Addendum No. 2

RE: Contract # C204507

Cumberland County (U-5798A)

SR-1102 FROM NORTH OF SR-1112 TO US-401 AND REPLACE BRIDGE
250075 OVER LITTLE ROCKFISH CREEK.

ALL BAR DIMENSIONS ARE OUT TO OUT.

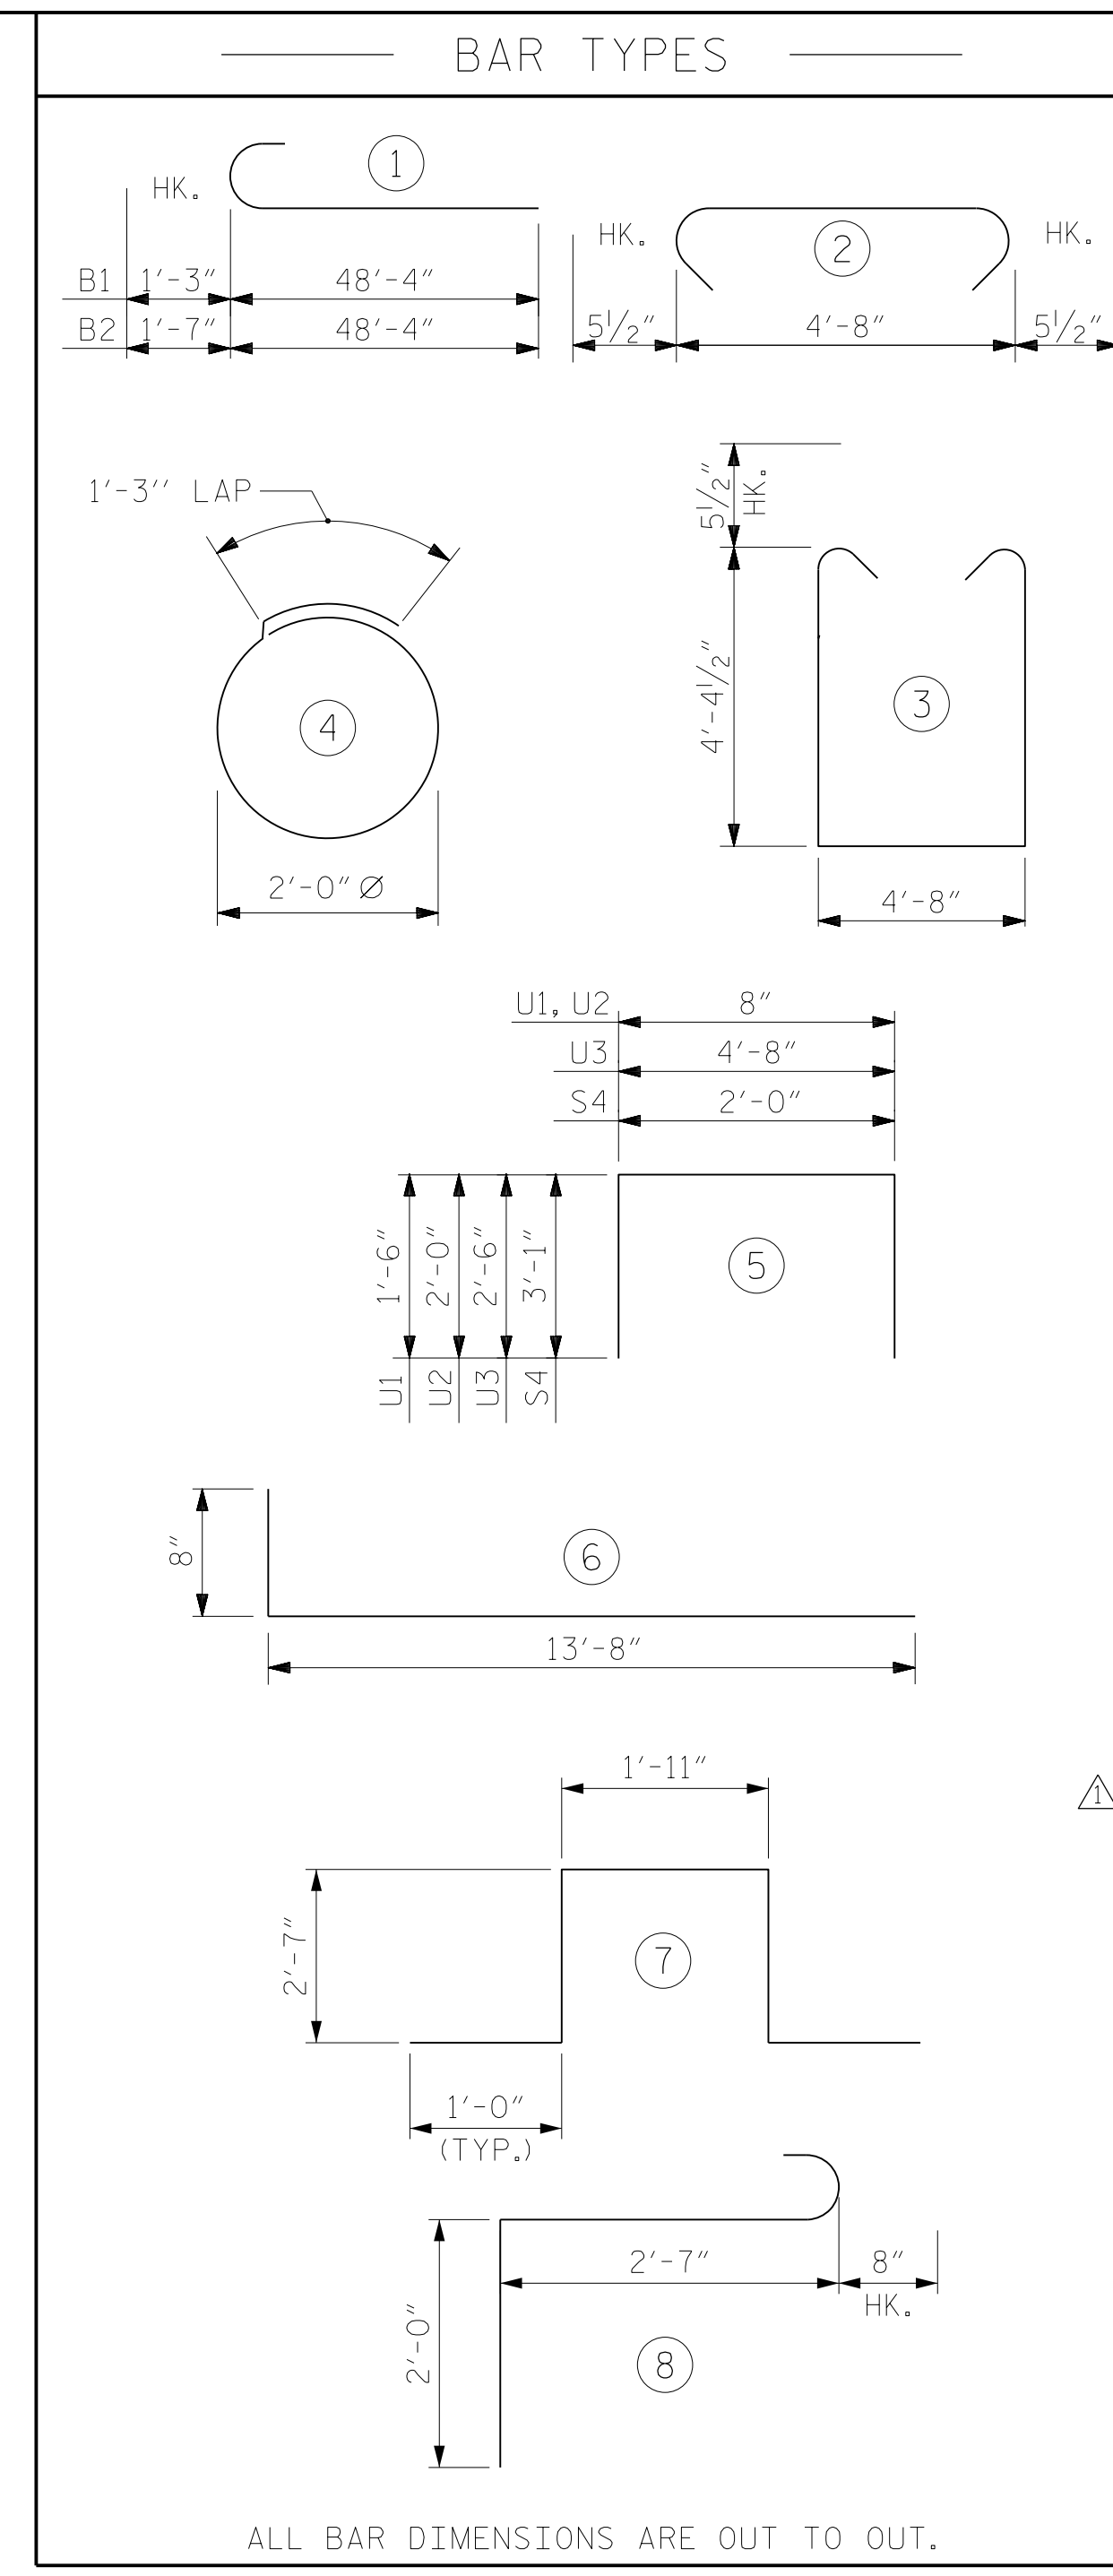
Sheet No.	Revision
S1-3	Updated to reflect quantity changes.
S1-33	Updated to reflect quantity changes.
S1-39	Updated to reflect quantity changes.
S2-3	Updated to reflect quantity changes.
S2-33	Updated to reflect quantity changes.
S2-39	Updated to reflect quantity changes.

<u>Item</u>	<u>Description</u>	<u>Old Quantity</u>	<u>New Quantity</u>
0240-8328200000-E-450	PILE DRIVING EQUIPMENT SETUP FOR HP 14 X 73 STEEL PILES	40 EA	44 EA
0242-8384000000-E-450	HP 14X73 STEEL PILES	2,580 LF	2,840 LF
